From: Bryan, Richard J.
Sent: 16 January 2024 17:35
To: Burrows, Joshua
Cc: WWW: Planning
Subject: Landscape RE: 24/0029/NOTAF- Pencoed Fach Farm Heol Y Cefn UPRN 000043087209
Attachments: ufm26_Consultation_(Notifications).pdf
Follow Up Flag: Follow up
Flag Status: Flagged
Categories: Amy

Subject: 24/0029/NOTAF- Pencoed Fach Farm Heol Y Cefn UPRN 000043087209

# Proposed new shed at Pencoed Fach Farm

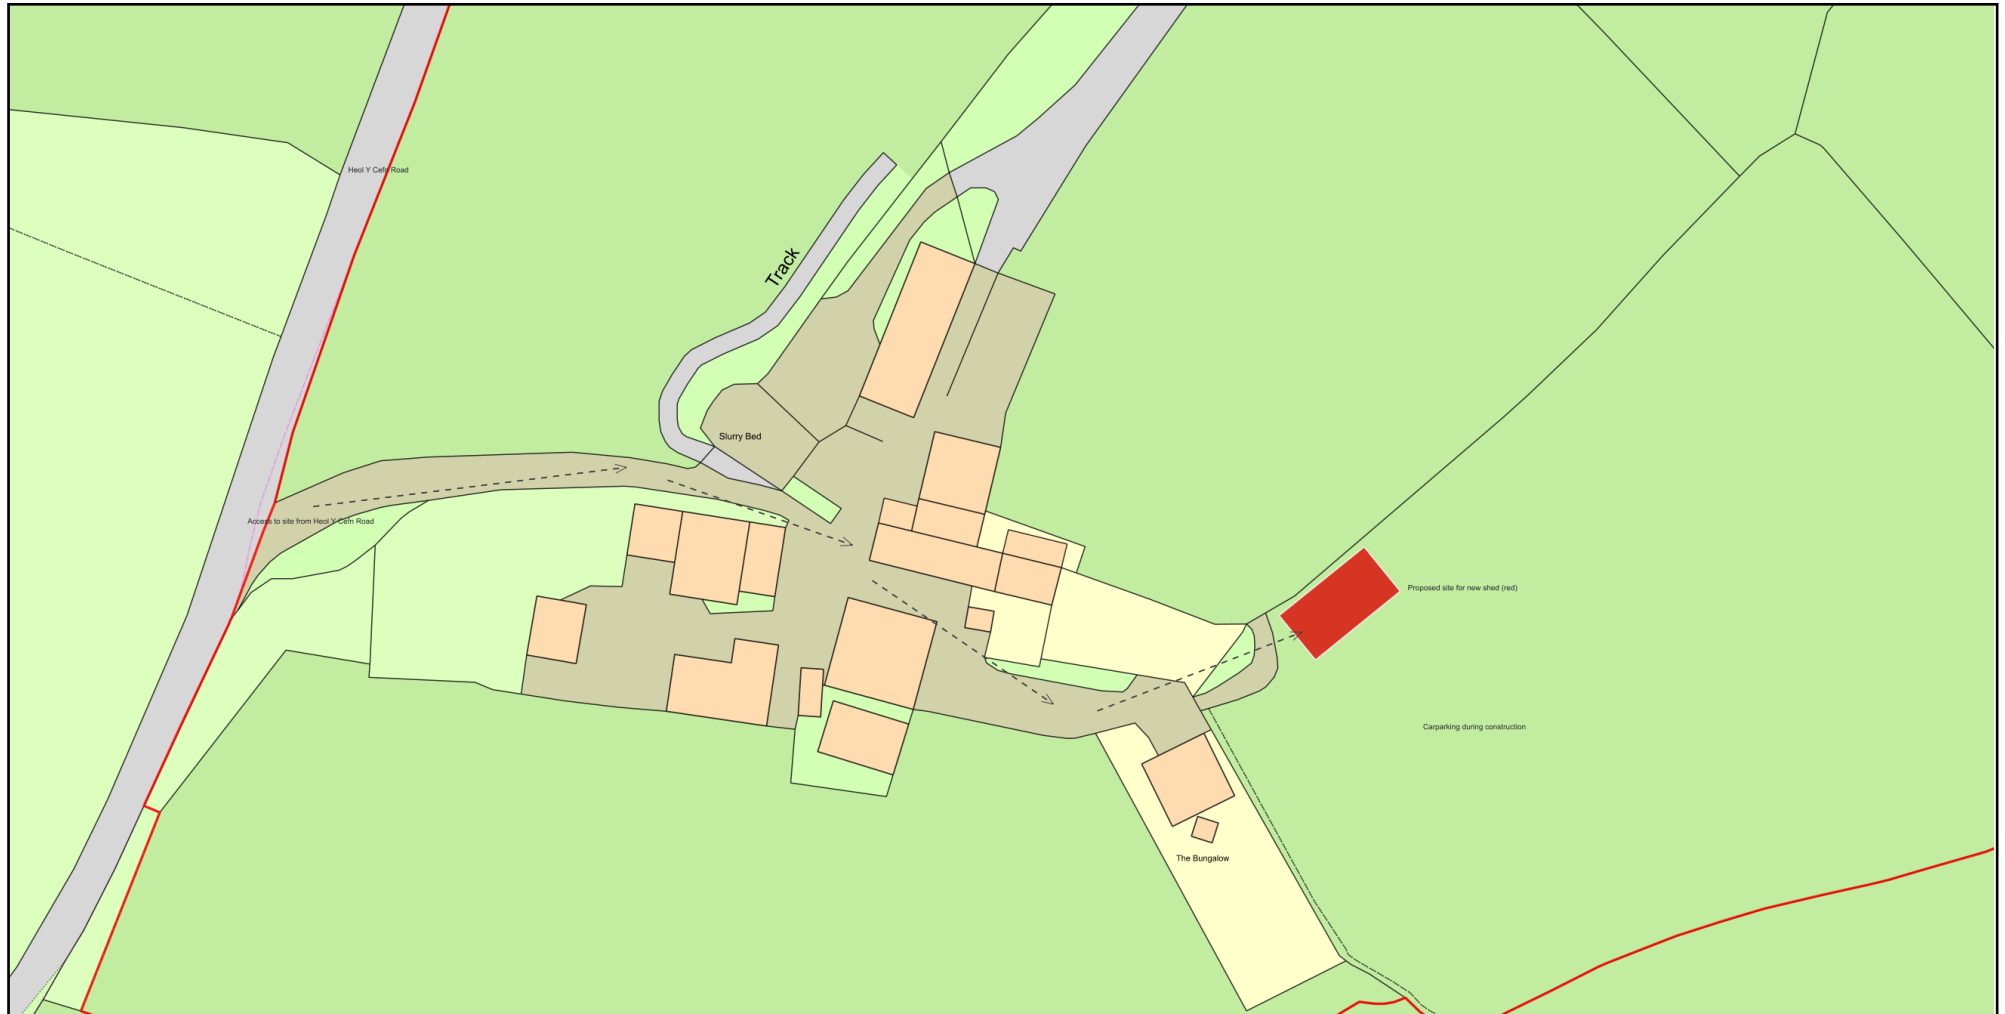
However, it's likely that sustainable drainage is required, and this is currently not shown on the plan. The application also lacks a Green Infrastructure statement, which are required.

Furthermore, its advised that roofing and wall materials should be dark in colour and non-reflective materials, to minimise the effect of glare and assist to blending the proposals in with their immediate surroundings.
